MECKLENBURG COUNTY
Land Use & Environmental Services Agency

MEMORANDUM

To: Charlotte-Mecklenburg Planning Commission
From: LUESA, Mecklenburg County
Date: 5.24.23
Subject: Rezoning Petition Comments

2022-200: IBM Drive Phase II residential

RZ-2

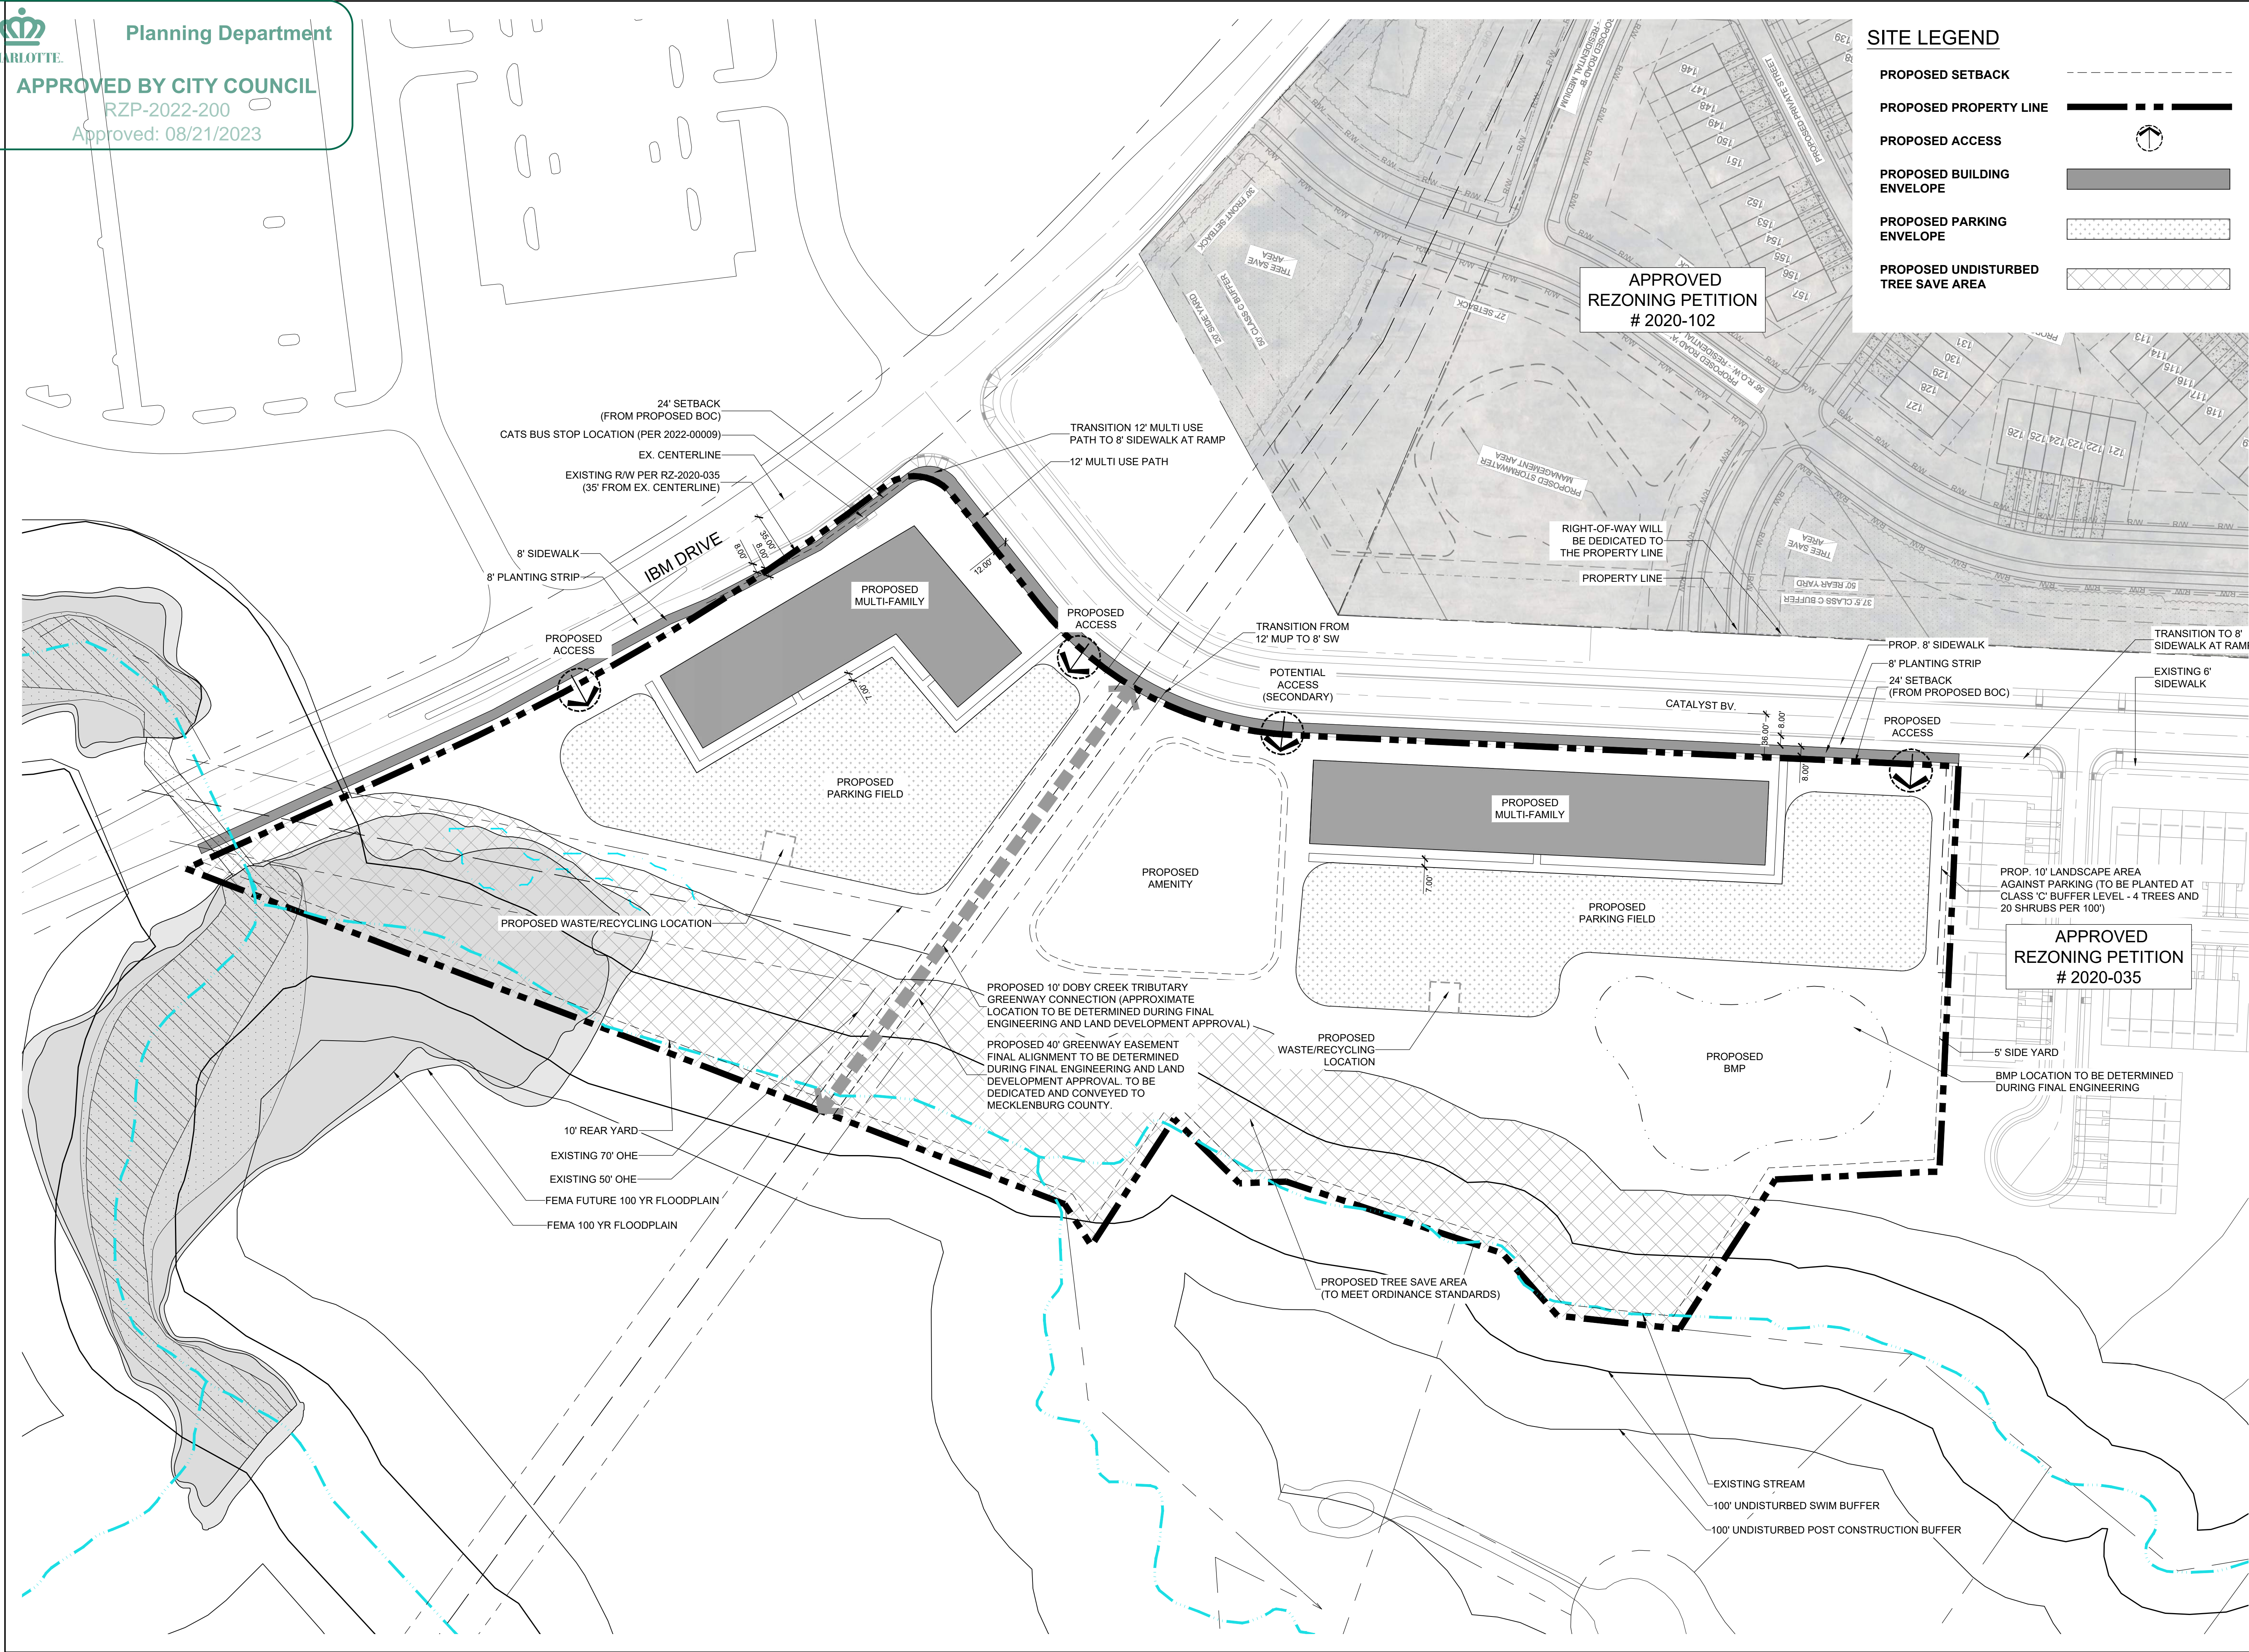
Storm Water Services Comments: A Floodplain Development permit must be obtained documenting compliance with the City of Charlotte Floodplain Regulations for all development occurring in the floodplain. In addition, staff recommend any structures proposed within the Community Special Flood Hazard Area be constructed to a Flood Protection Elevation equal to the Community Base Flood Elevation plus two (2) feet of freeboard based upon recent analyses of the future floodplains supported by the Storm Water Advisory Committee.
